CITY OF ALBUQUERQUE

Re: Cielito Lindo
5109 Central NW
Traffic Circulation Layout
Architect's Stamp dated 12-05-16 (K11-D085)

Re: Cielito Lindo
5109 Central
Traffic Circulation Layout
Architect's Stamp XX-XX-XX (K11-D085)

A1.2

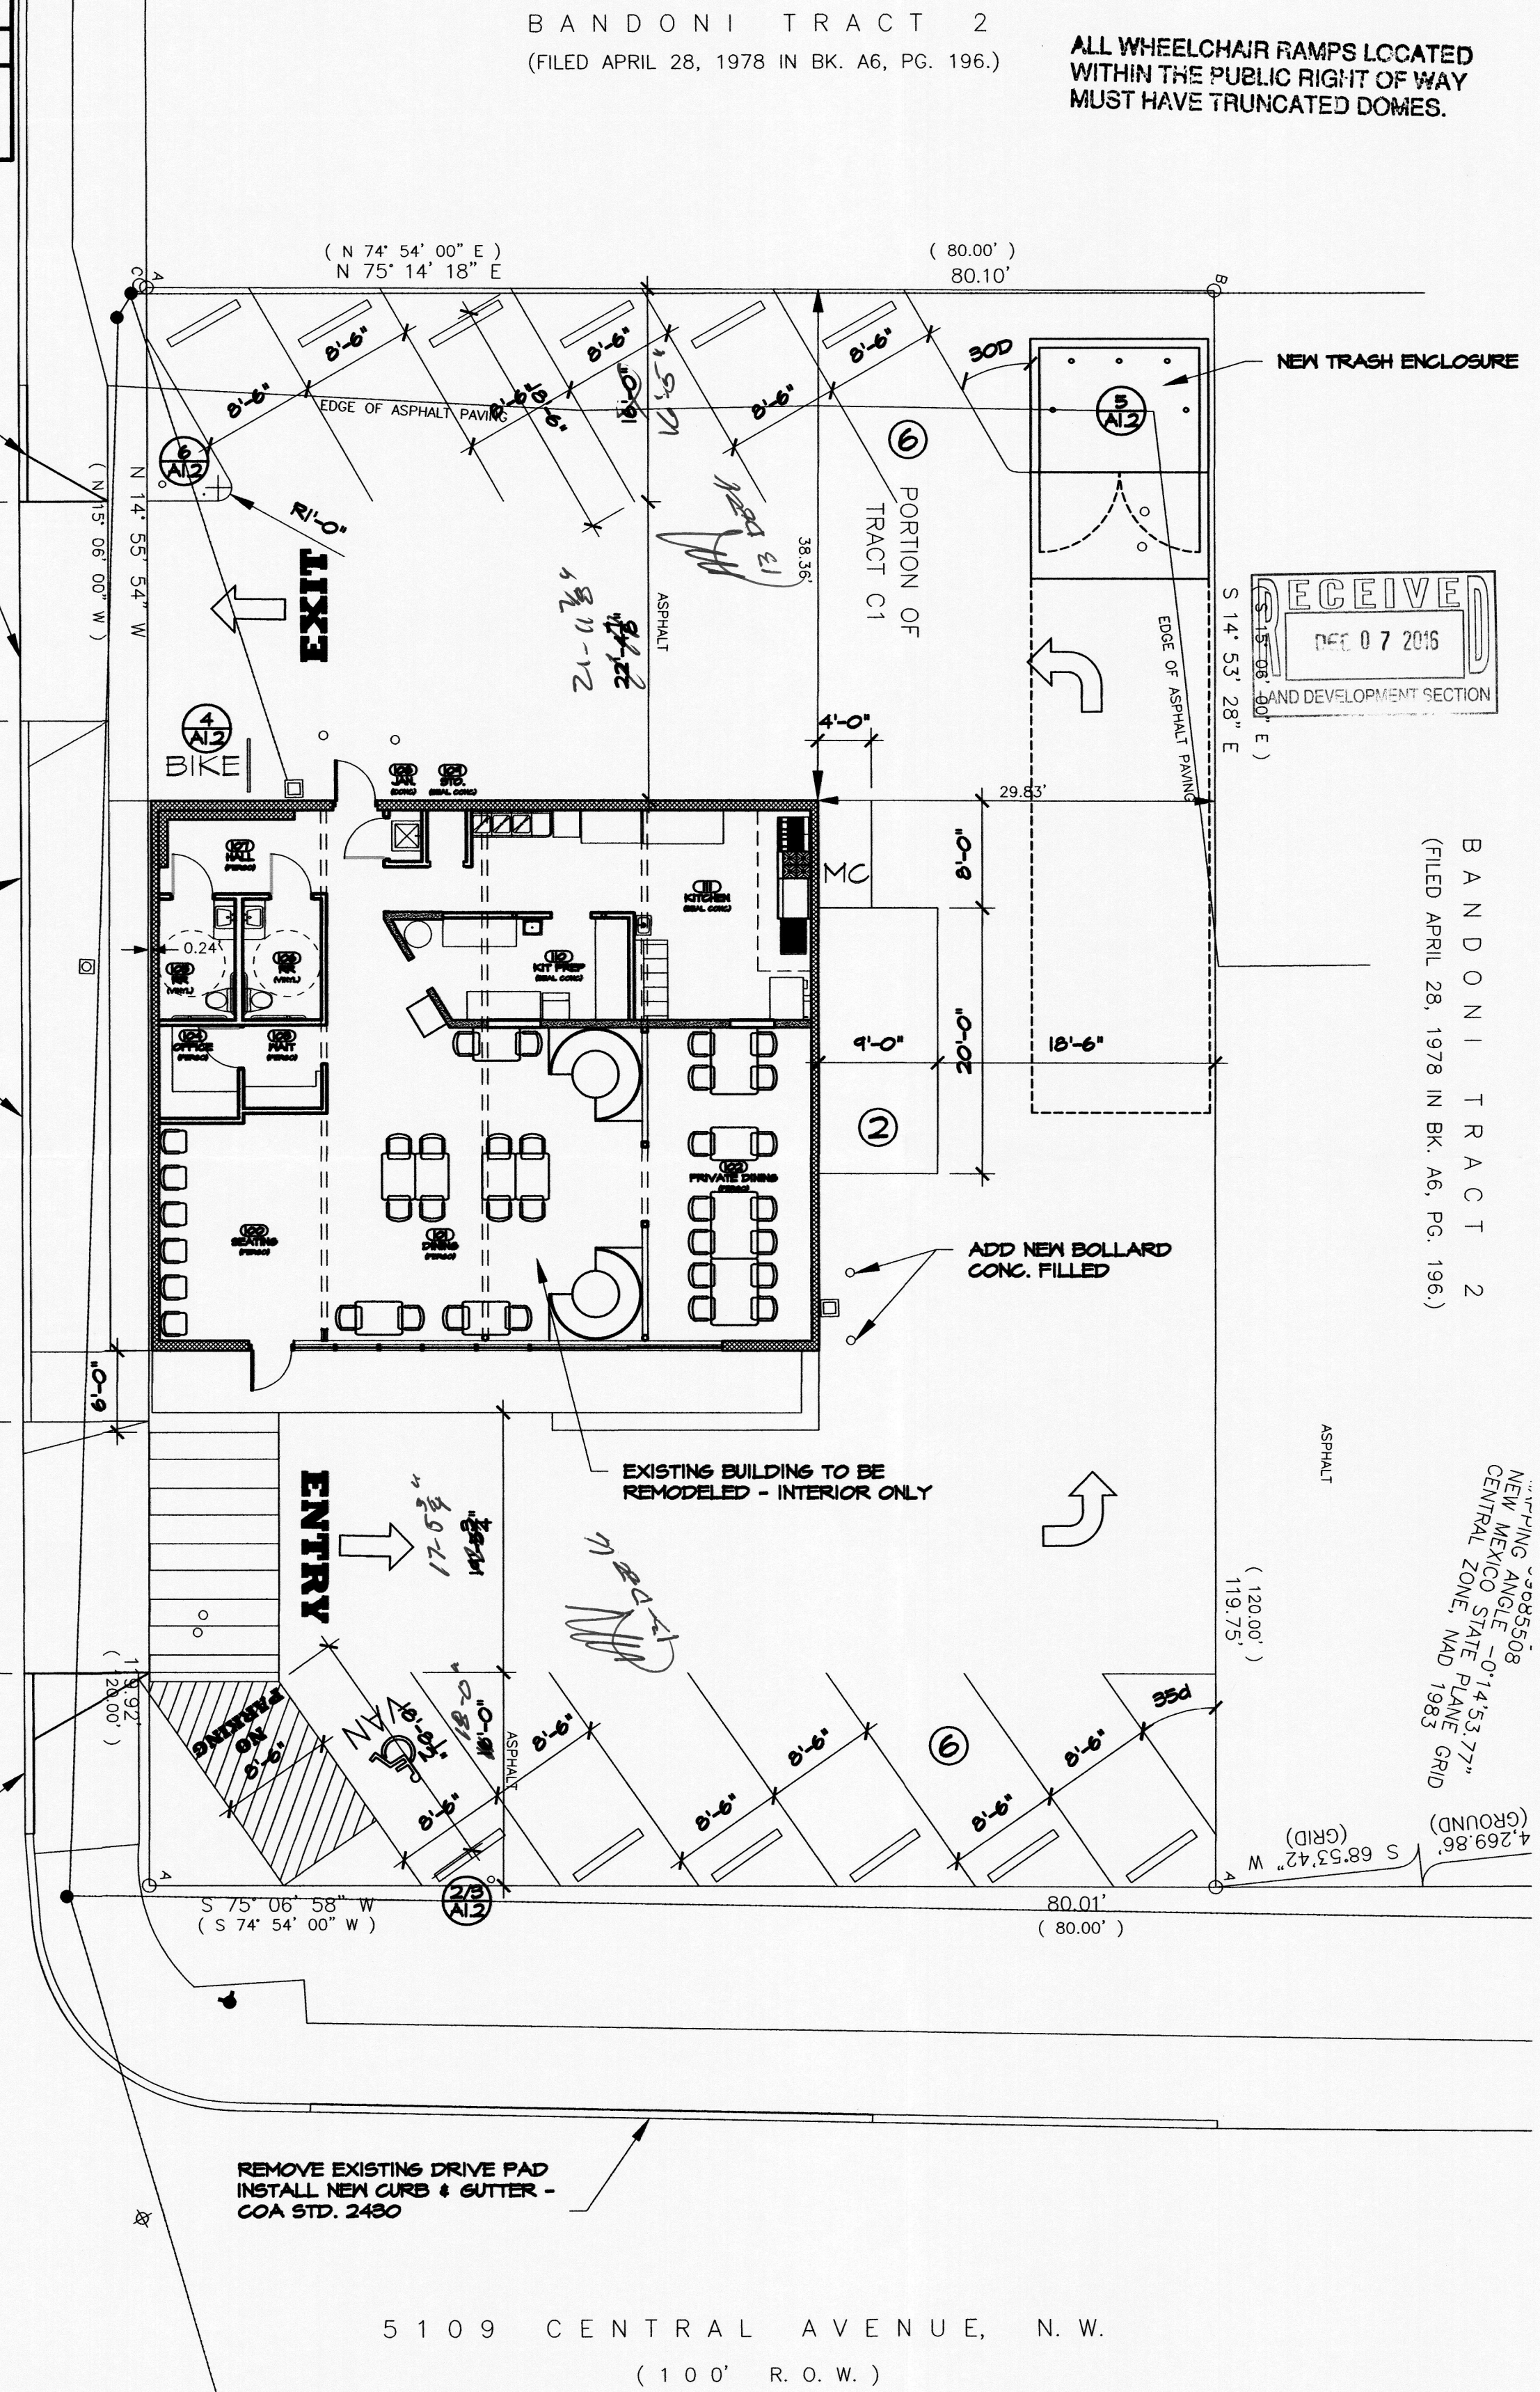
The parking stalls are still short in length. The you may want to consider extending aisle and reduce the entrance.

The 35 degree angle parking should be about 17' 4" per DPM Figure 23.7.1.

The 30 degree angle should be 16' 5". This is all with an 18 foot aisle. You are showing 16' on both.

1. Please review and revise plan to provide all information listed on the attached Traffic Circulation Layout checklist.
2. The traffic circulation layout must be stamped, signed, and dated by an engineer or architect licensed in the state of New Mexico.

3. Please show a vicinity map showing the location of the development in relation to streets and well known landmarks.
4. List the number of parking spaces required by the zoning code as well as the proposed number of parking spaces including bicycle and motorcycle parking.

5. Dimension the drive aisle widths to the bollards.
6. Show the angle of the parking stalls. See Chapter 23, Section 7 of the City of Albuquerque *Development Process Manual*, for parking stall layout dimensions.

7. Per the zoning code, a 6 ft. wide ADA accessible pedestrian pathway is required from the public sidewalk to the building entrances. Please clearly show this pathway and provide details.

8. Please clarify the building frontage. Will there be a step added?
9. Refuse vehicle maneuvering should follow the vehicular path.
10. One-way vehicular paths require pavement directional signage and a posted **"Do Not Enter"** sign at the point of egress. Please show detail and location of posted signs.
